From: Simon Davis
Sent: 25 August 2021 12:26
To: 'Susan Leeson' [REDACTED]
Subject: RE: Brookview Nursery WA/58/21/PL

I consider that the proposal accords with ALP EMP DM1 and with WNP CL1. However, CL2 does resist new B8 development so I would propose (with your agreement) restricting any PP to B1 (now E(g)) uses only.

Existing Block Plan
Scale 1:500

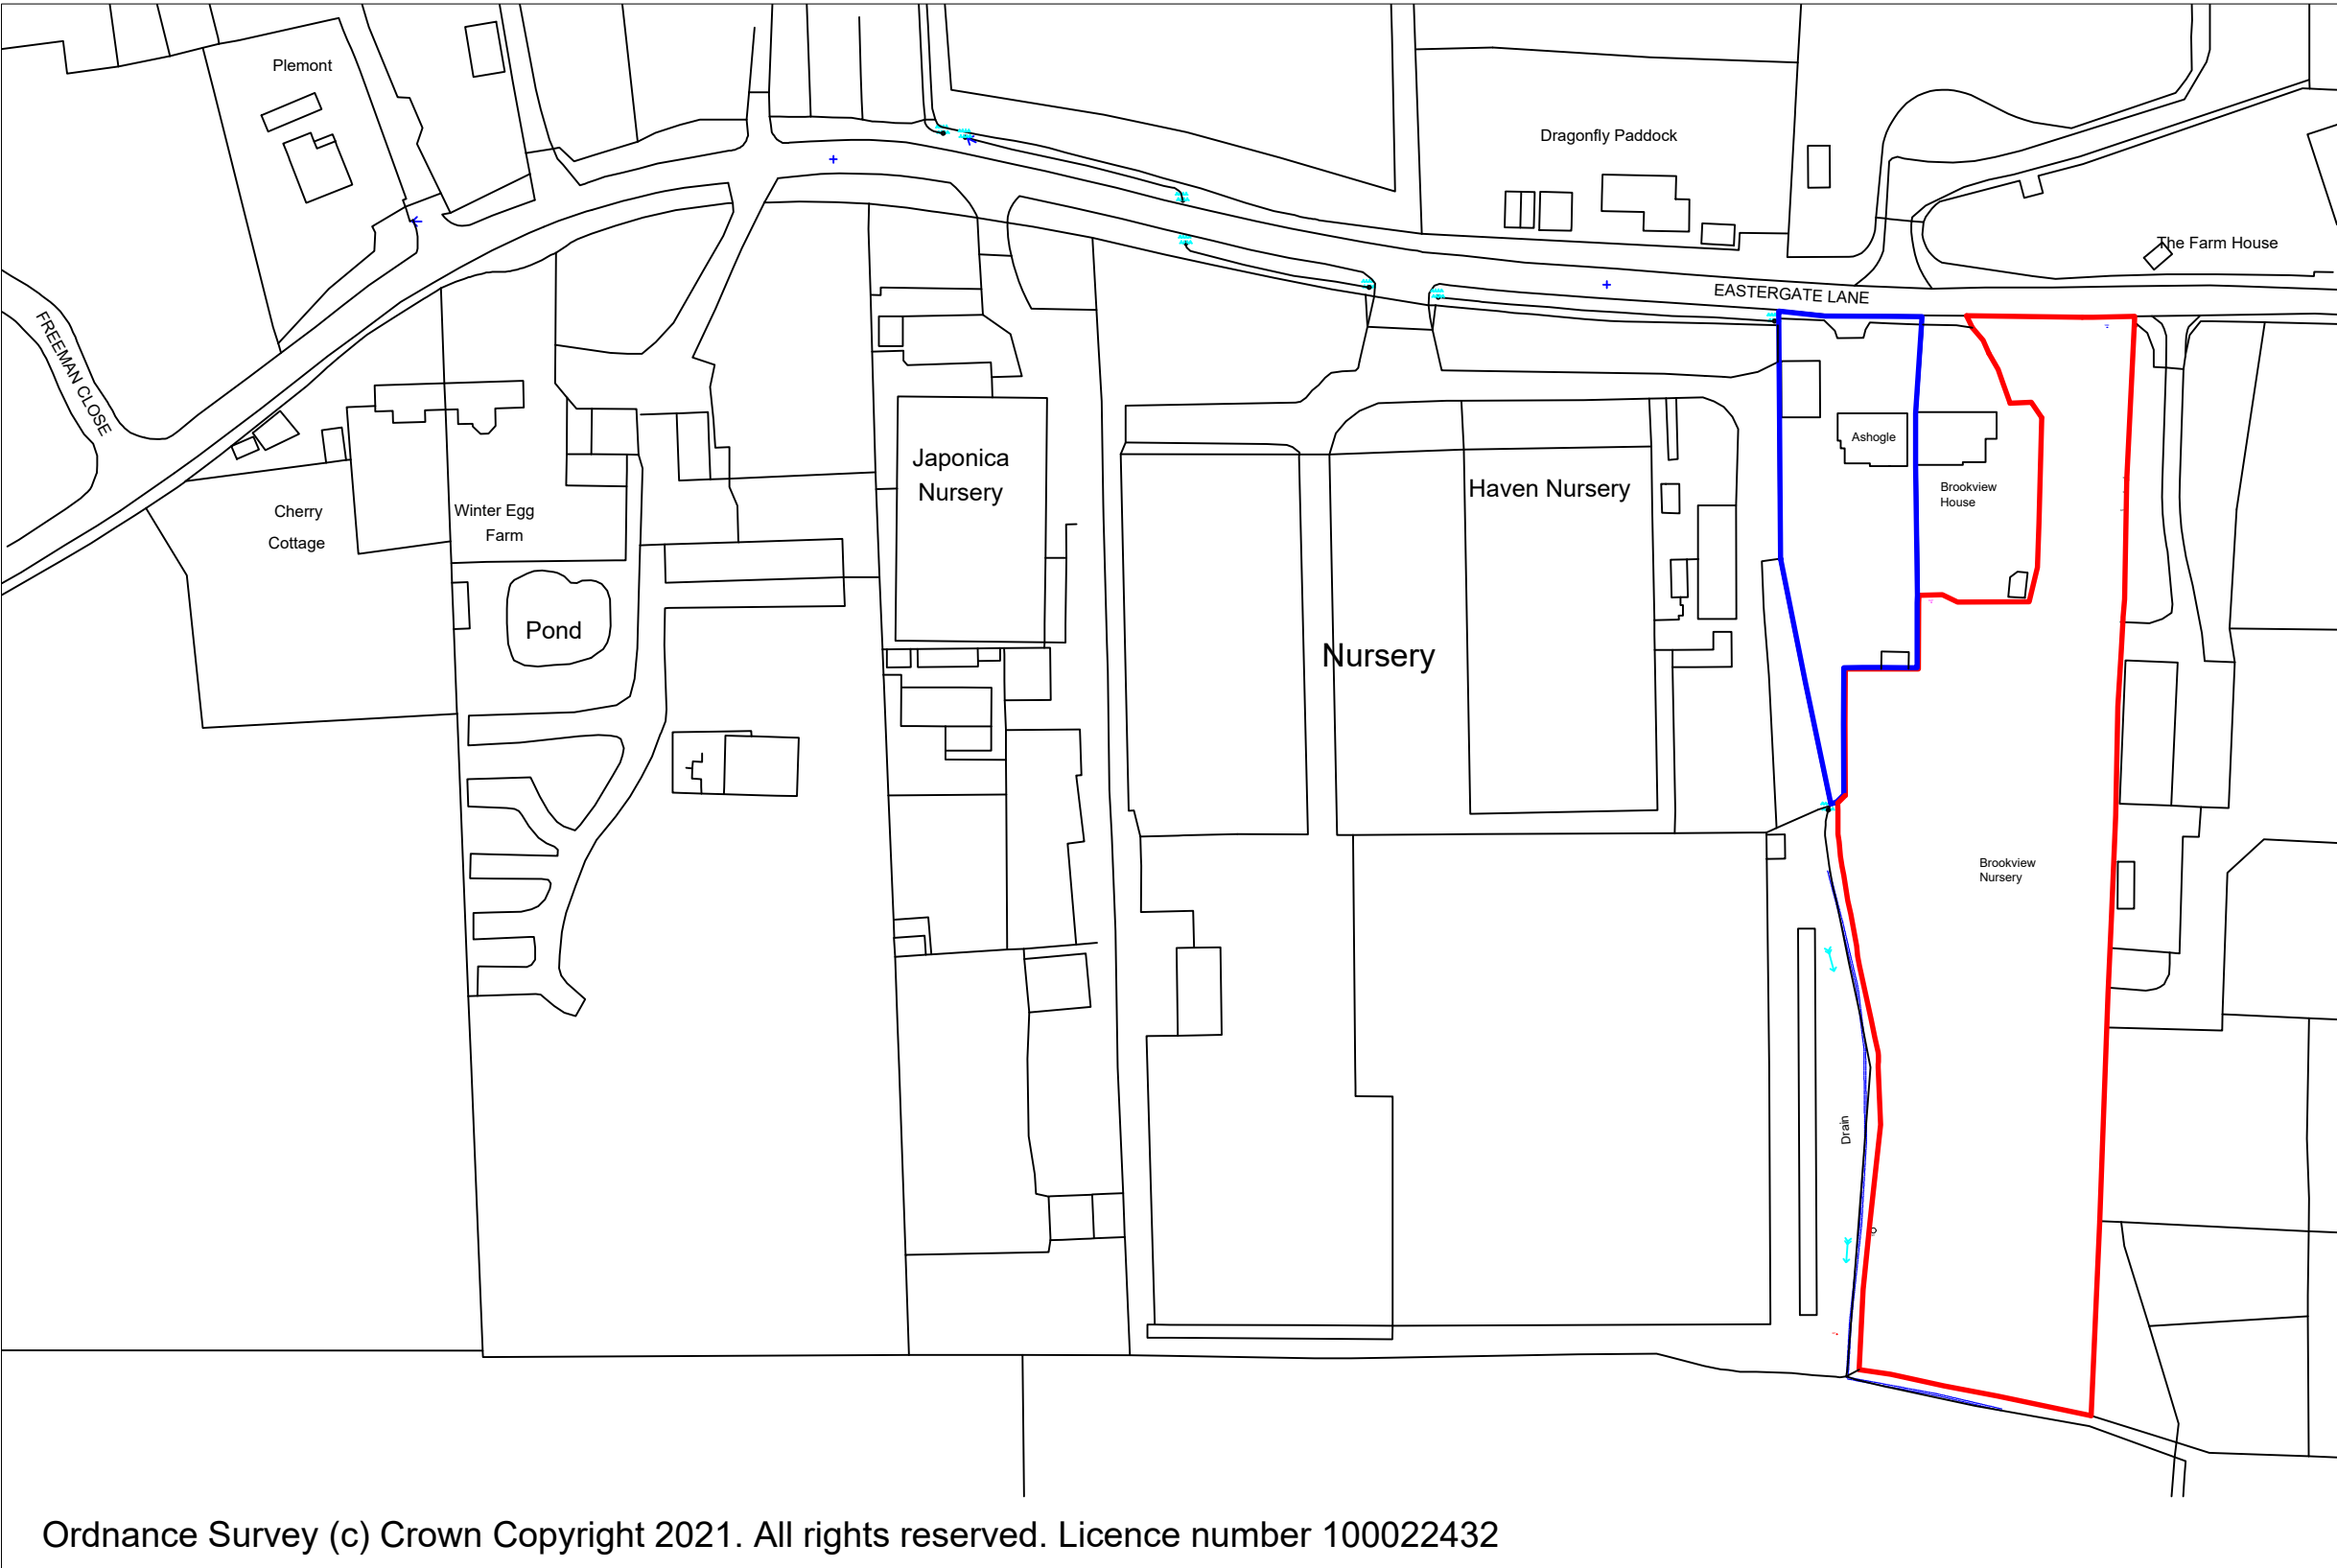
Anyway, I note that you are proposing to remove trees along the western and southern boundaries and so I think you would be in conflict with policy VE10 which states:

This conflict is likely going to make this very difficult to get through the DC Committee. You may be able to resolve this by layout changes/biodiversity net gain proposals.

Further speaking of which, you have not provided any tree survey so we cannot assess the impact on trees. I have consulted the Tree Officer but if he does respond, he will only say that no tree survey has been provided. Sorry for not spotting this previously but this does need to be provided.
